**CITY OF PORTLAND**

August 22, 2001

RE: 29 Hall Street: Fill Permit Application  
(#2001-0180) (CBL 159 A001001)

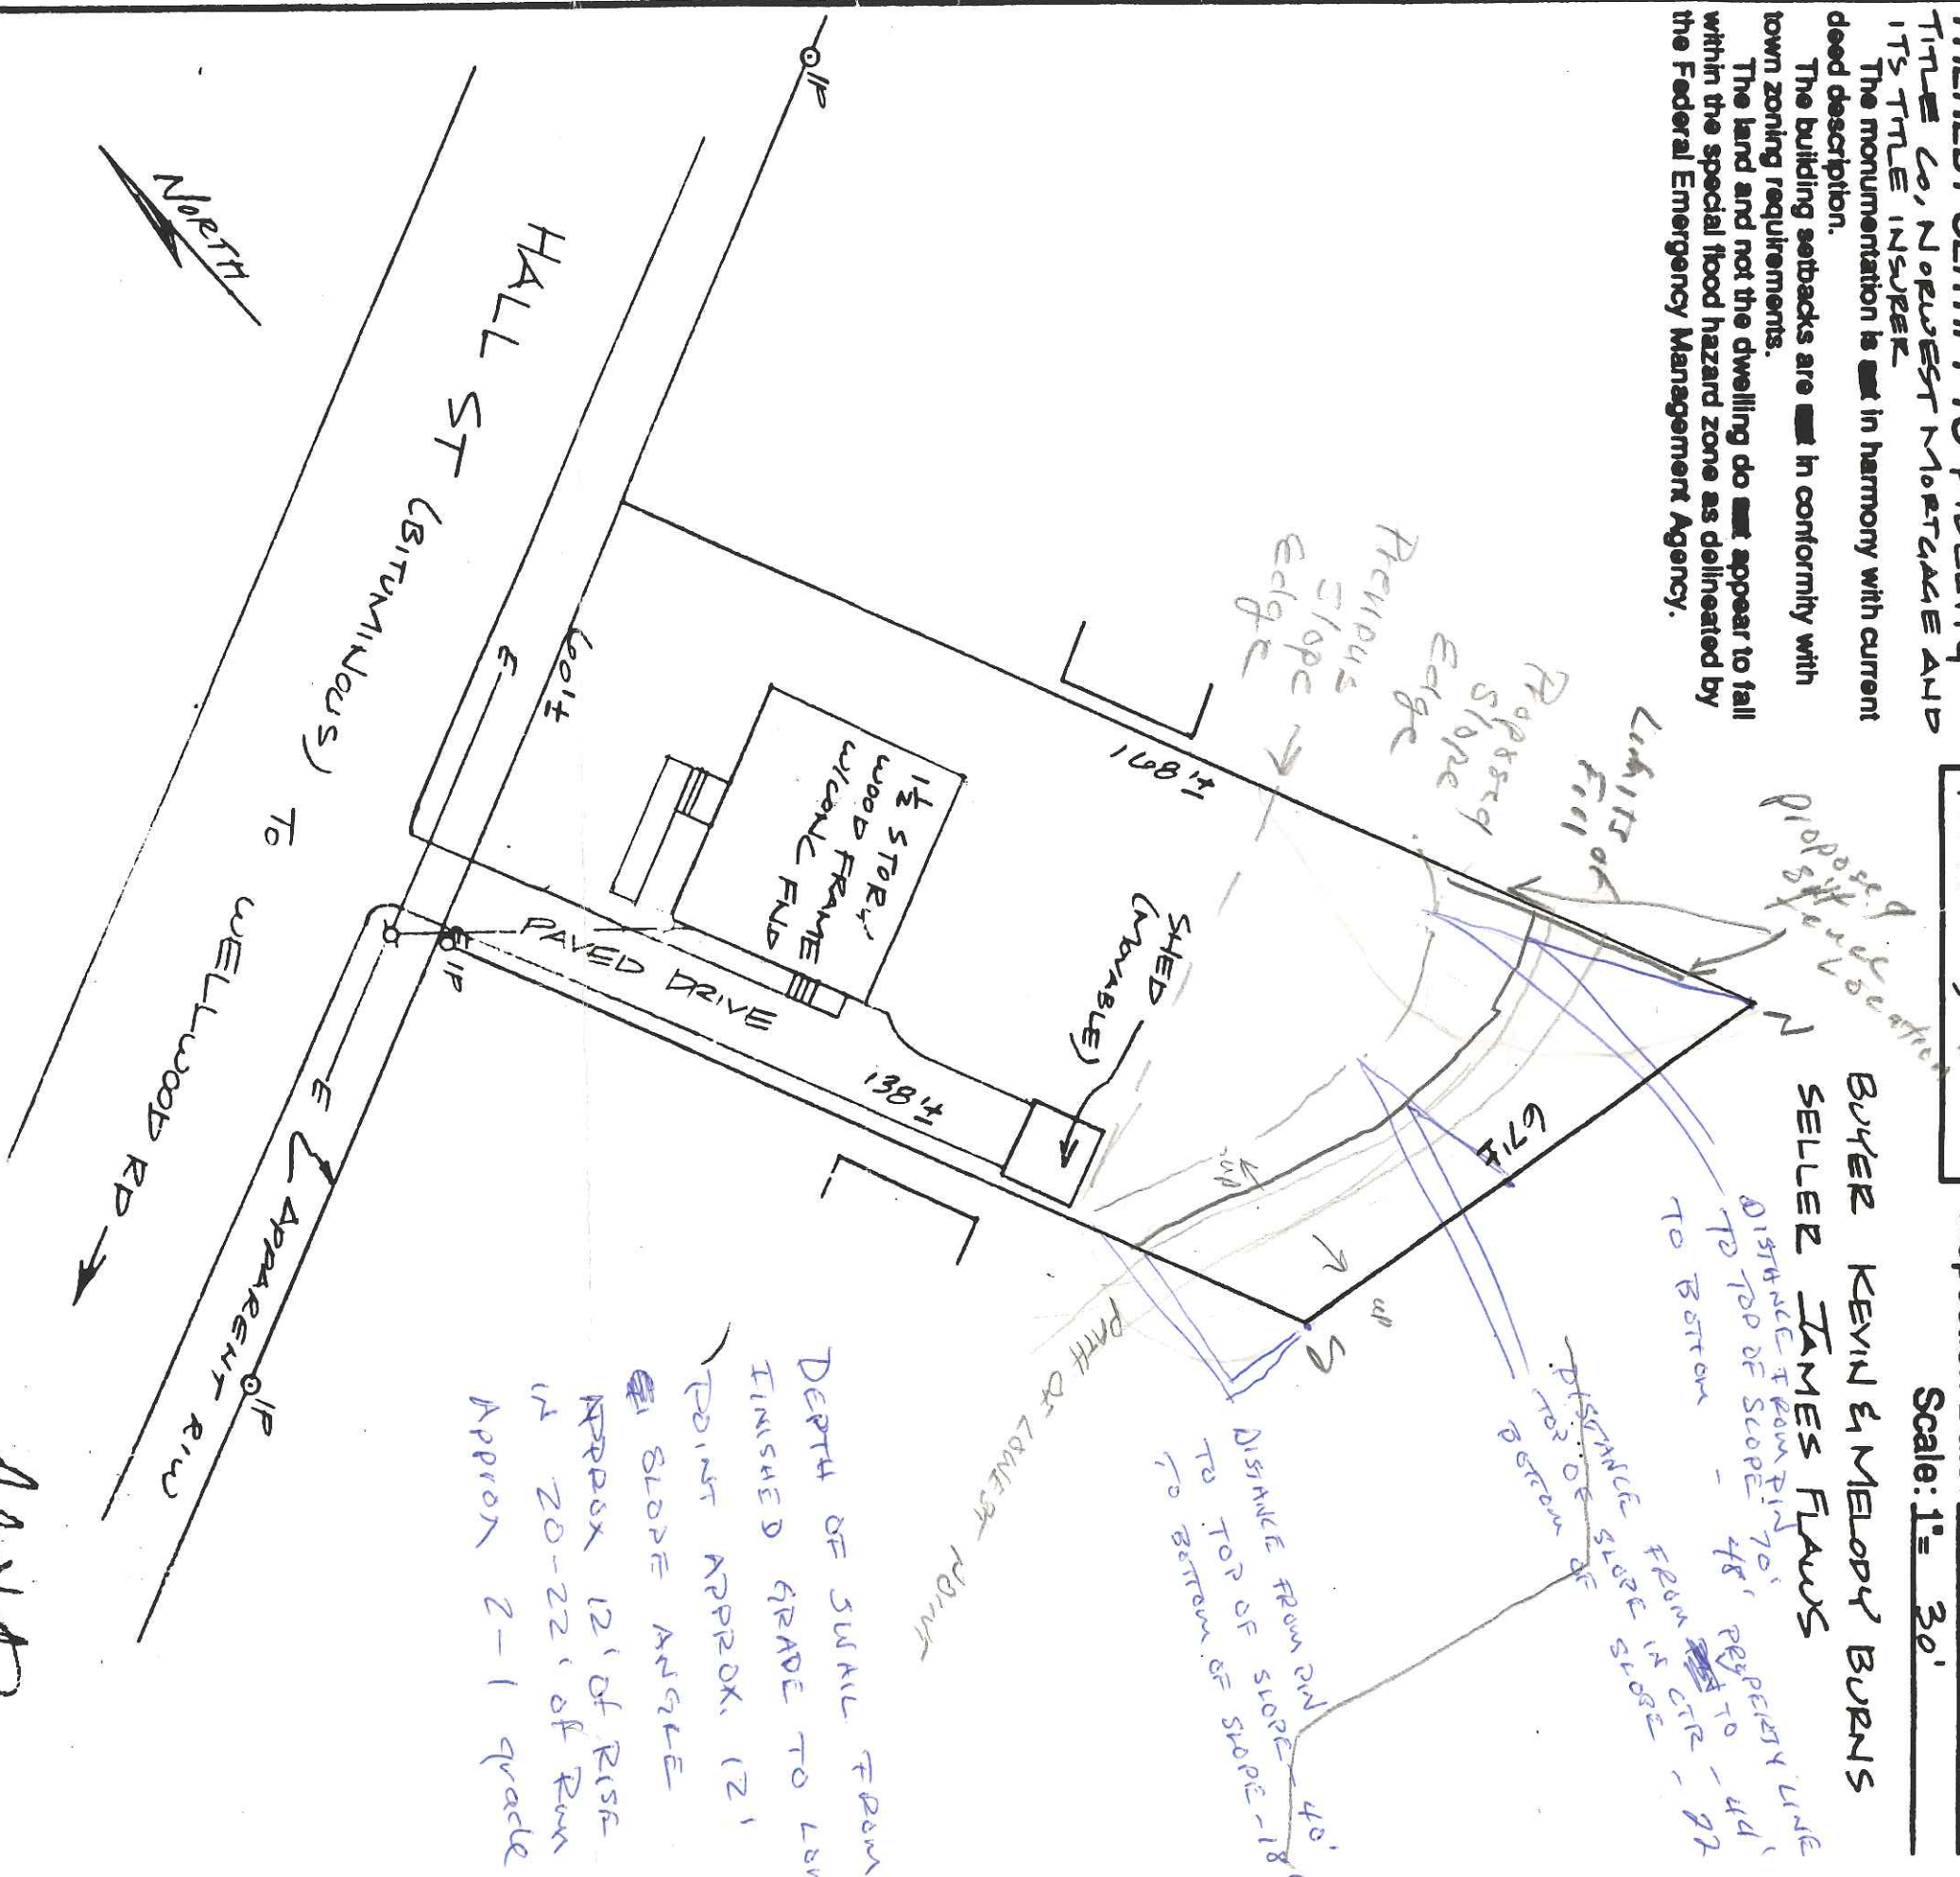
Your prior and proposed fill area is in a wetland area, and also infringes on the Fall Brook floodplain as shown on the Federal FIRM maps.

Your 1994 fill permit did not permit you to fill or alter wetlands and/or floodplains. As a result of the above facts, the city is denying your application.
